**Project Name**  
 Birdworld & Haskins Forest Lodge  
 Farnham Road, Holt Pound,  
 Farnham GU10 4LD

## **APPENDIX B.** HCC Pre-Application Meeting Minutes

## **APPENDIX C. HCC Pre-Application Responses**

Thank you for your pre-application enquiry into the proposed expansion of Birdworld and Forest Lodge garden centre located to the north of Bucks Horn Oak.

DRAWN	CHECKED	APPROVED
MC	MC	SAW
PROJECT No:	SCALE @ A1:	DATE:
ITB16329	AS SHOWN	12.10.23
DRAWING No:	REV:	
ITB16329-GA-106	E

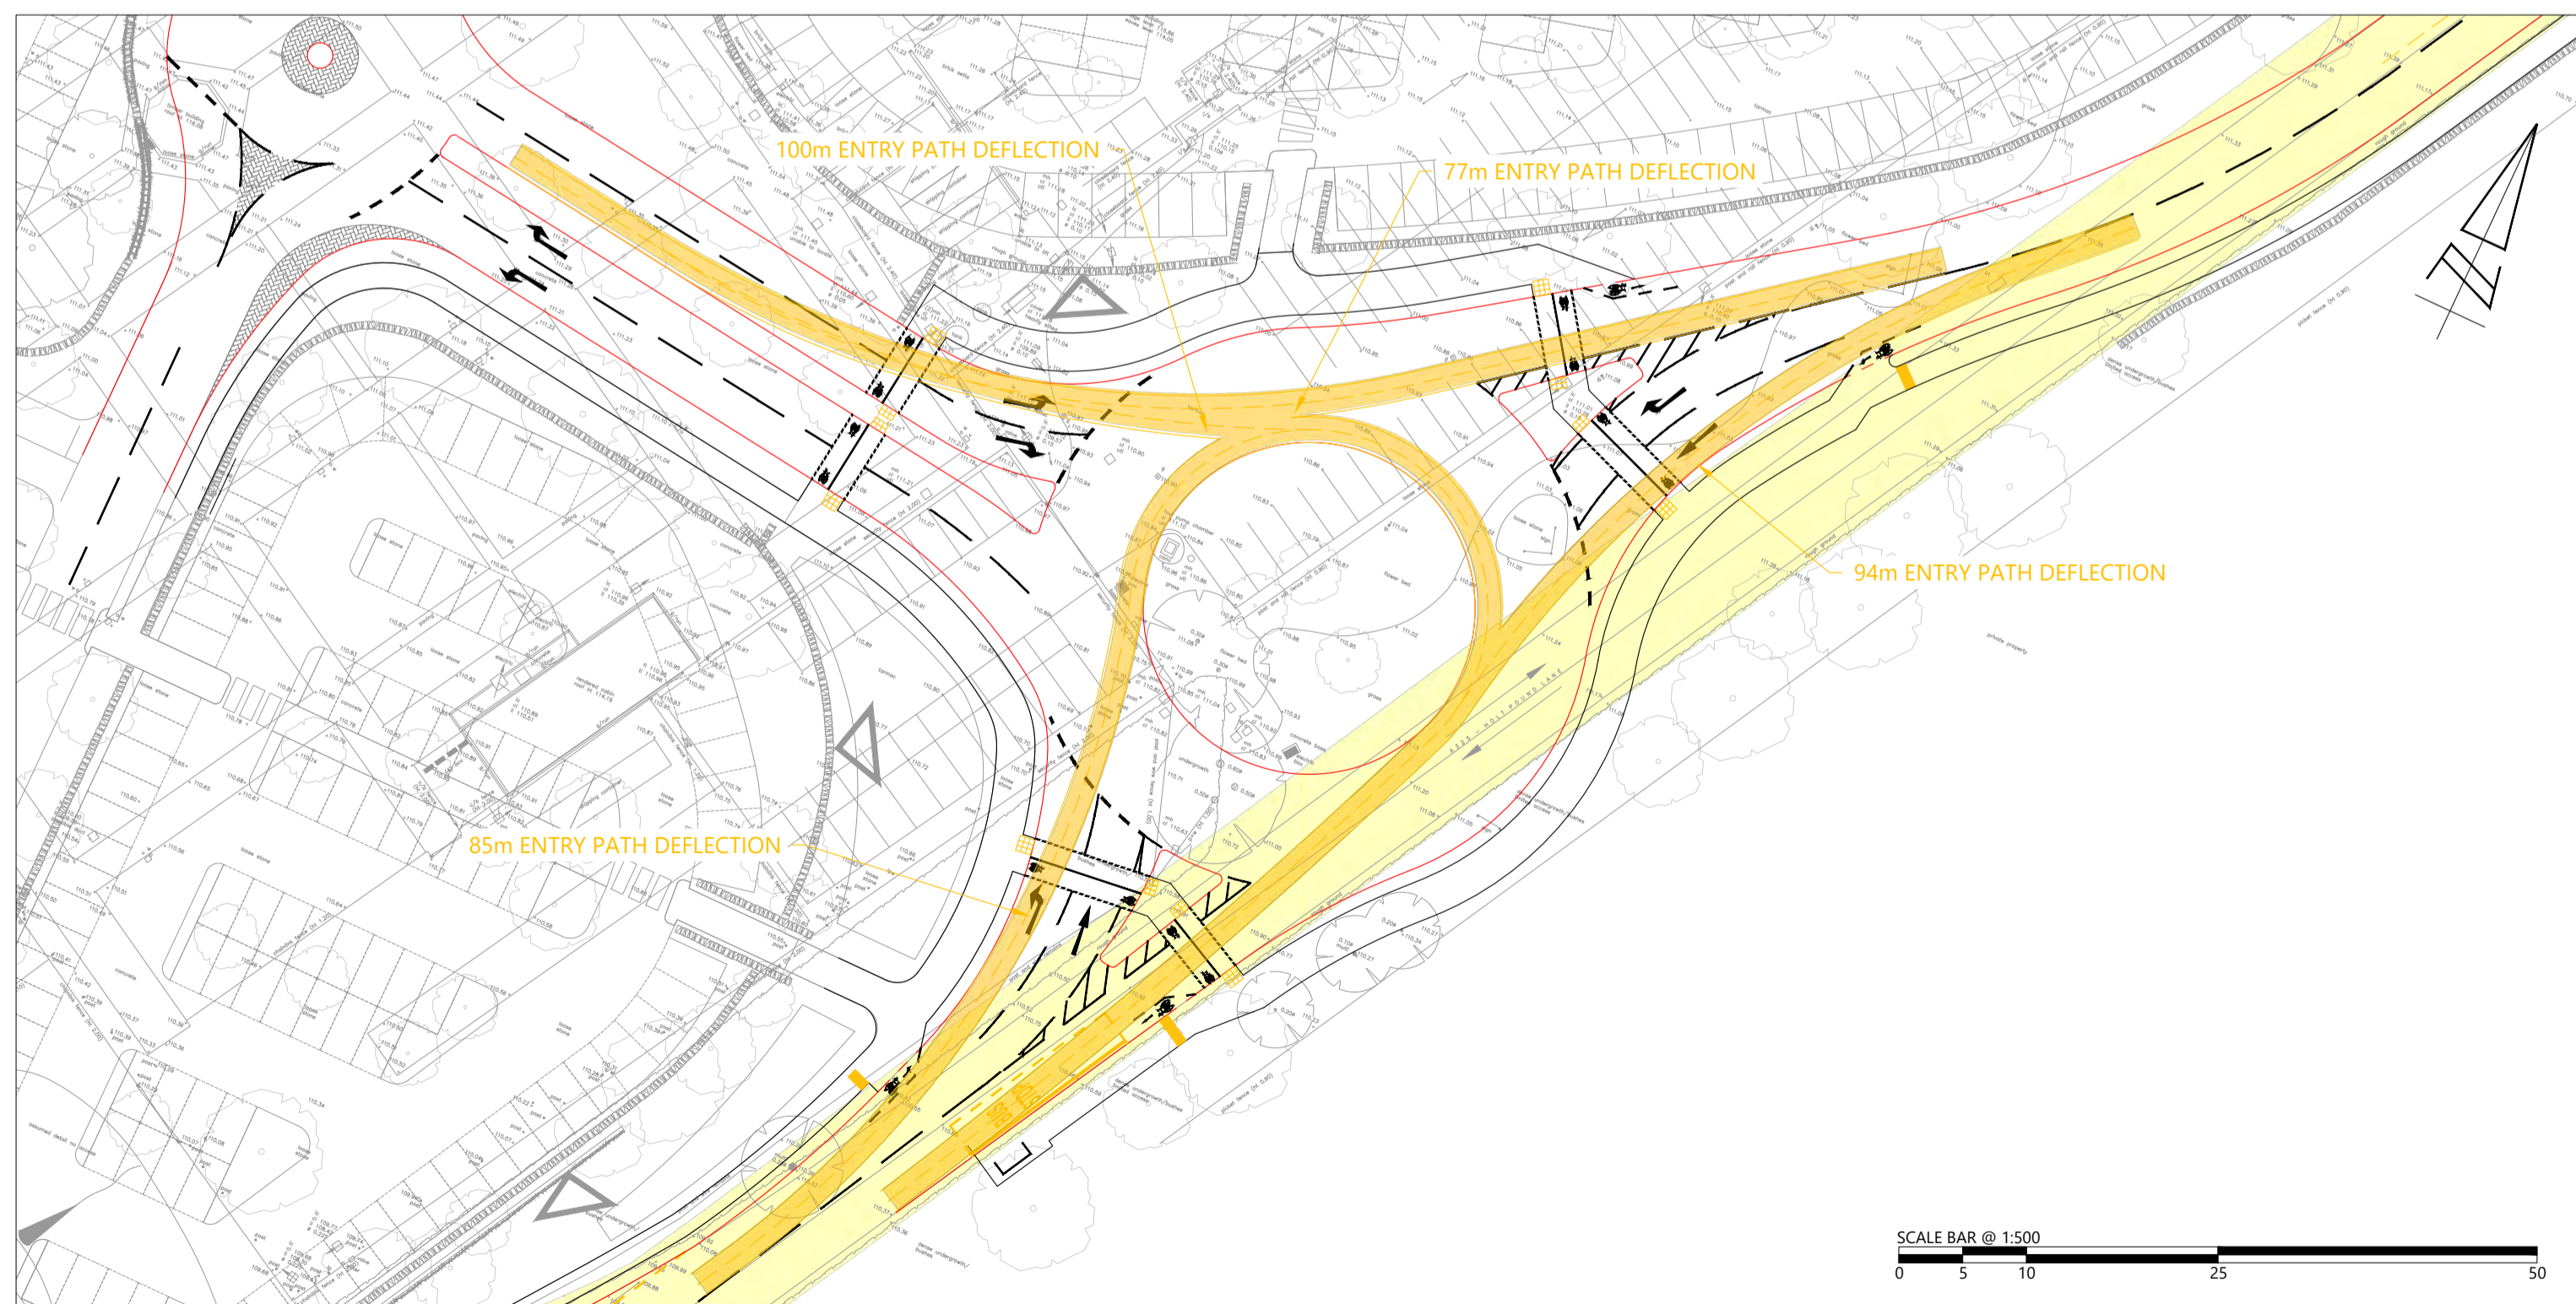
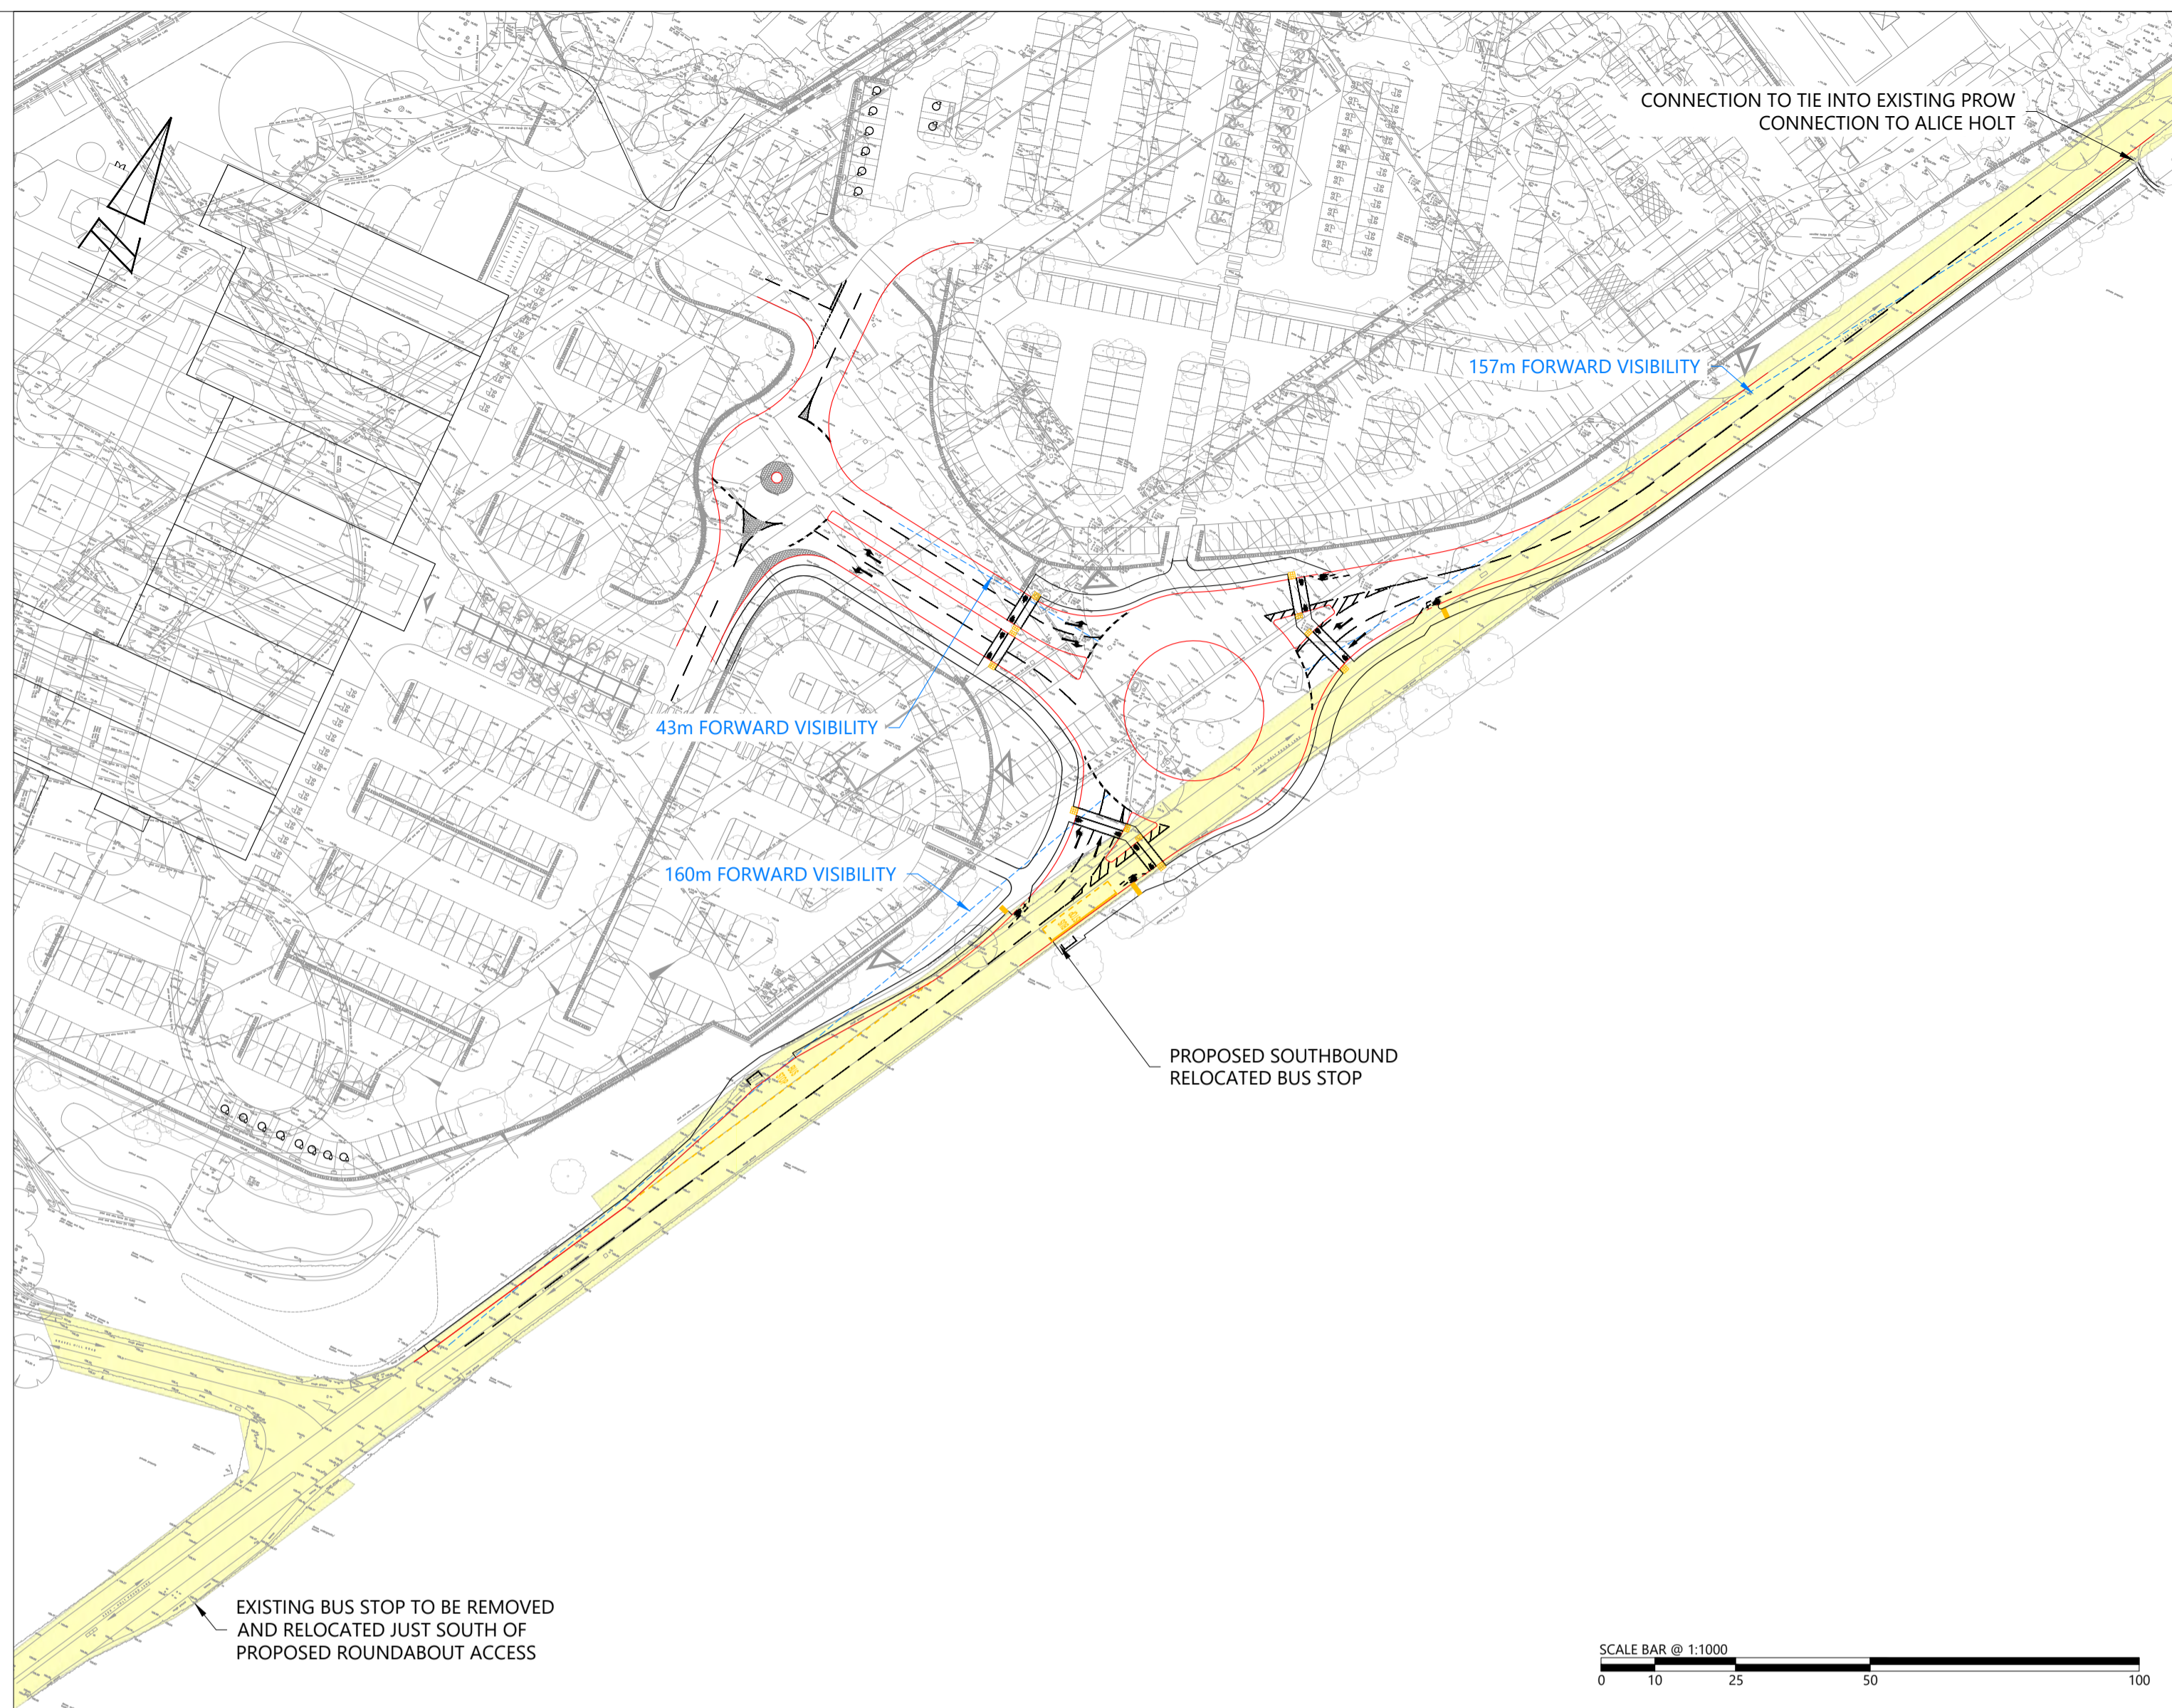
The southbound bus stop currently consists of a flag pole and timetable only. The applicant should investigate whether it is possible to provide a bus shelter in this location which would help to encourage the uptake of bus provision by providing dedicated waiting facilities. This would be especially beneficial given the current infrequency of the bus service.
